Reference No:	2026/62/91154/W
Site Address:	Plot 147 The Warkworth at Victoria Heights, 28, Bridge View, Fixby, Huddersfield, HD2 2GS
Description:	Erection of first floor extension above existing garage
Recommending Officer:	James Evans

DECISION - REFUSE

Officer Report – 2026/91154

PROPOSED FRONT ELEVATION
SCALE 1:50 @ A1

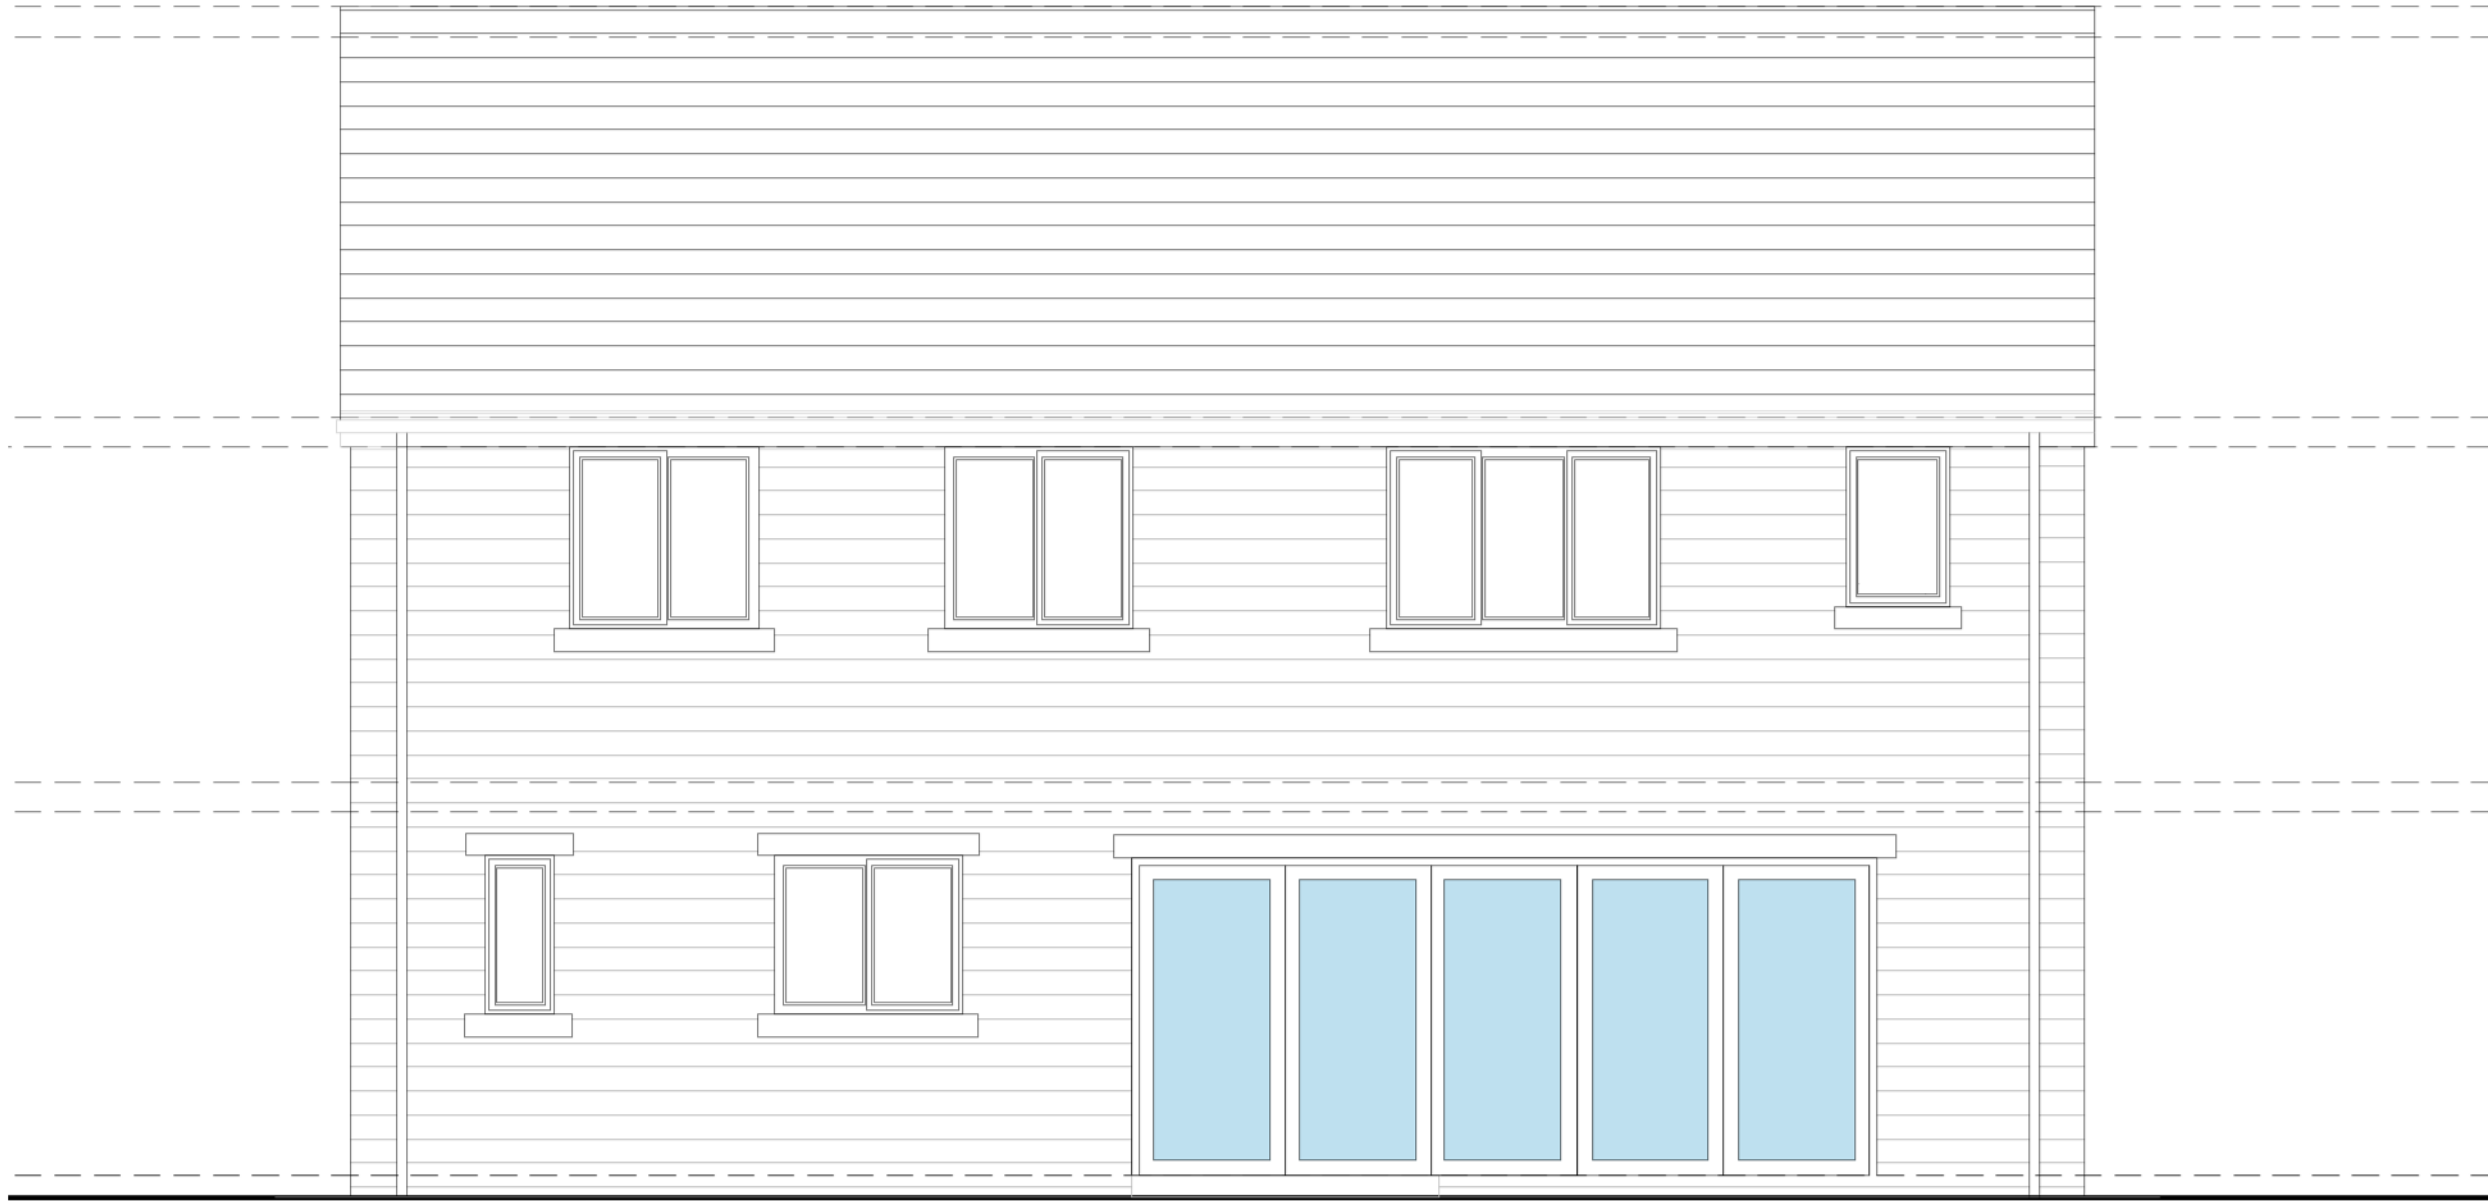
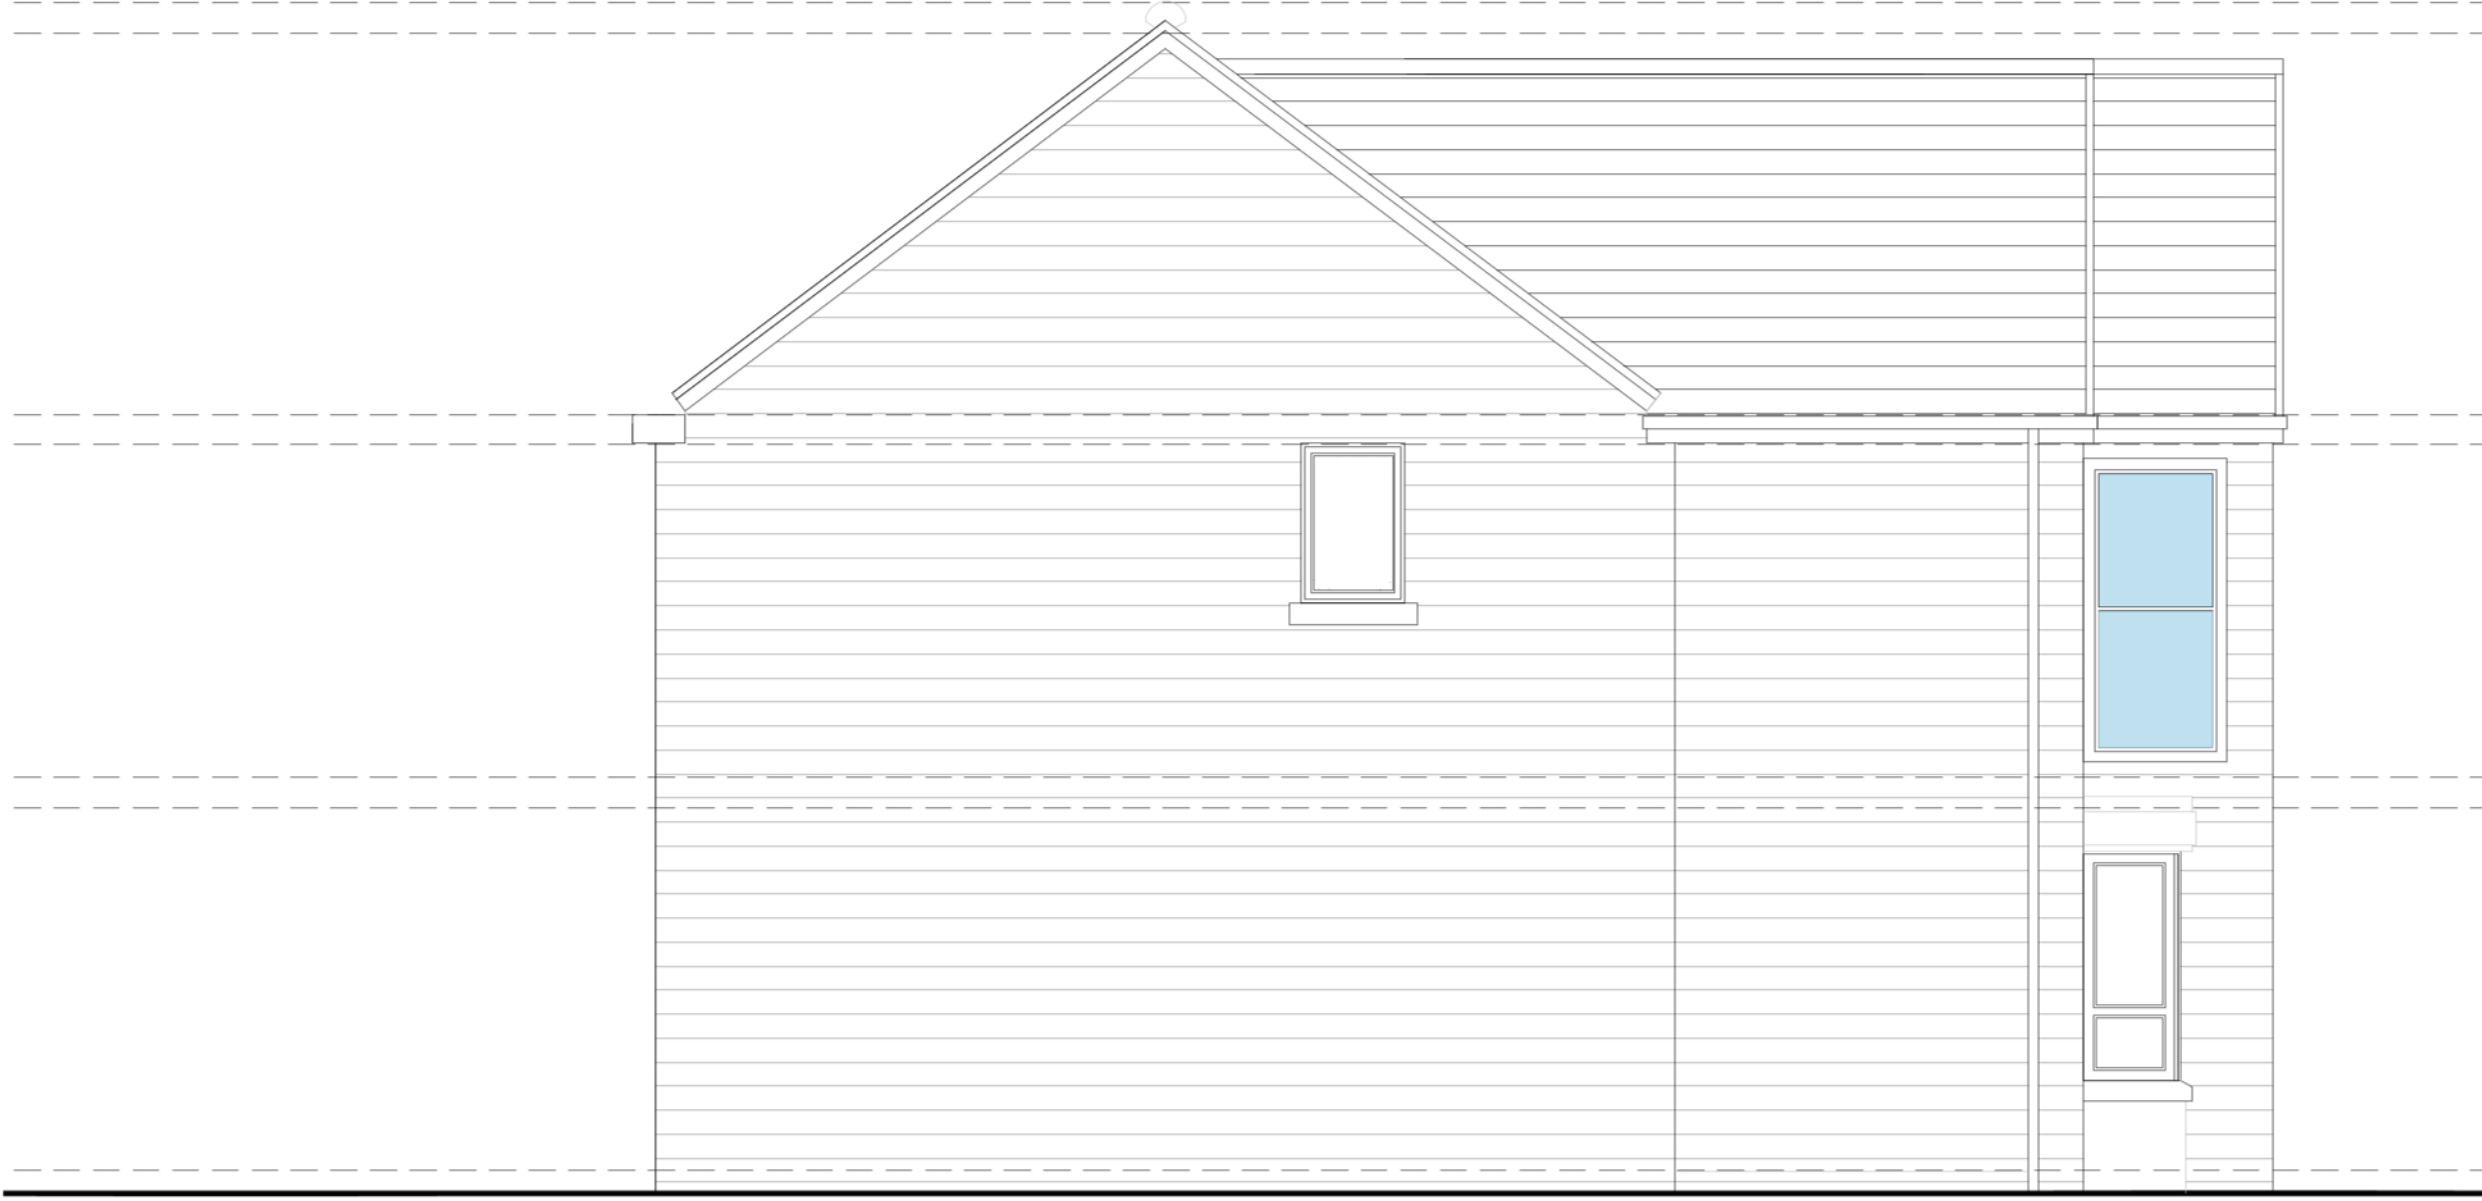
The most prominent feature of the extension is the large expanse of glazing to the front, with a width of 4.2m and a maximum height of 4.4m. This amount of glazing is not sympathetic to the design of the property, and it appears a dominant addition to the dwelling. The surrounding properties do not feature glazing to this scale, therefore this would be an incongruous addition to the street scene, especially due to its location to the front of the property.

The proposed extension will also add an additional gable to the front elevation of the existing building. Whilst it is noted that some buildings within the wider housing development site do have two gables (plots 178, 179, 182 and 185), these dwellings are located on different streets to the application site and also have appropriate amounts of glazing. On this basis, the proposal would therefore it would not be in keeping with the character of the street scene.

1. The proposed extension, by virtue of its scale and design, would result in the creation of an incongruous feature within the street scene and would detract from the existing character within the area, to the detriment of visual amenity. To permit this development would be contrary to Policy LP24 of the Kirklees Local Plan, KDP1 & KDP2 of the House Extensions and Alterations SPD and advice within Chapter 14 of the National Planning Policy Framework.

PROPOSED FIRST FLOOR PLAN
SCALE 1:50 @ A1

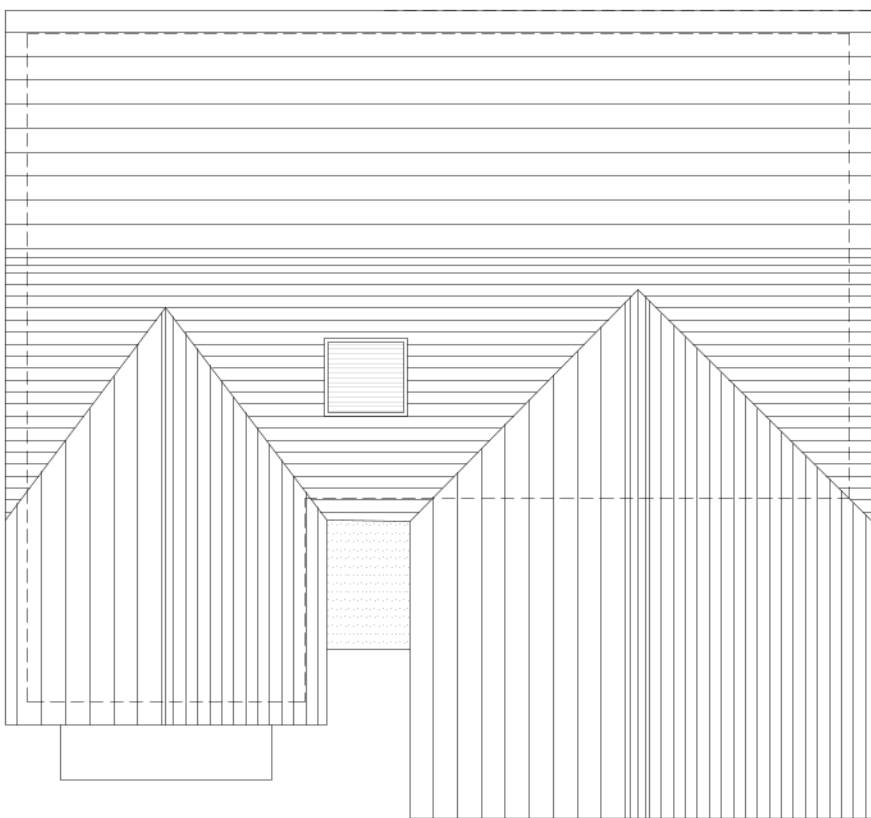
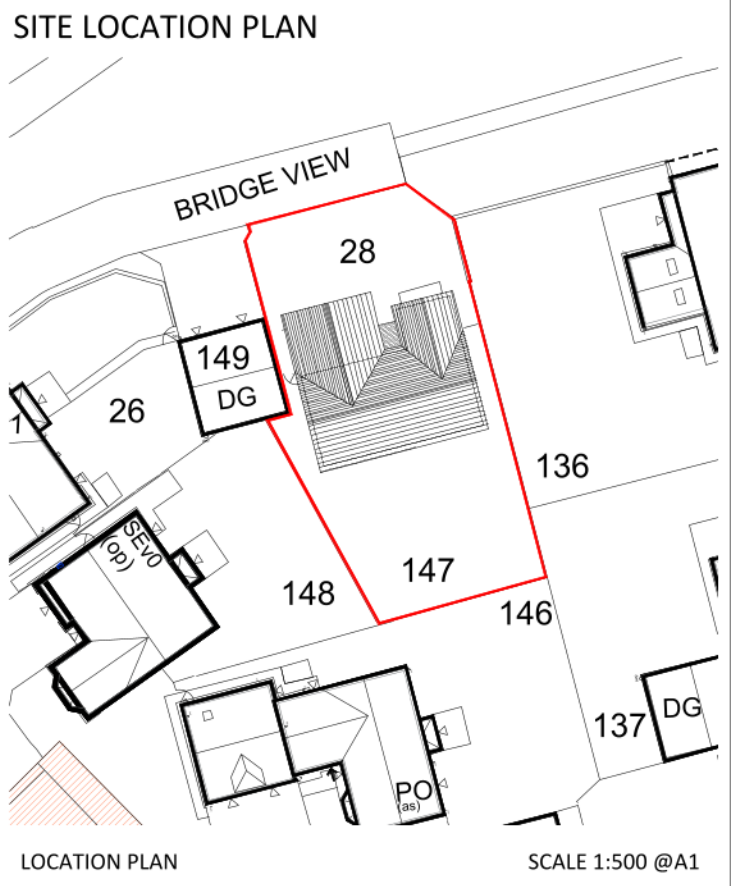
The proposed extension will be adding an additional opening to the east of the existing dwelling. This opening will face in the direction of plot 136, and will face onto habitable rooms on the ground and first floor levels. It will host a habitable room and will be 19.6m away from the openings at plot 136. This is less than the recommended 21m between facing windows of habitable rooms. However, due to the distance being only just under the recommendation, and the small scale of the side window, this is not considered grounds for refusal.
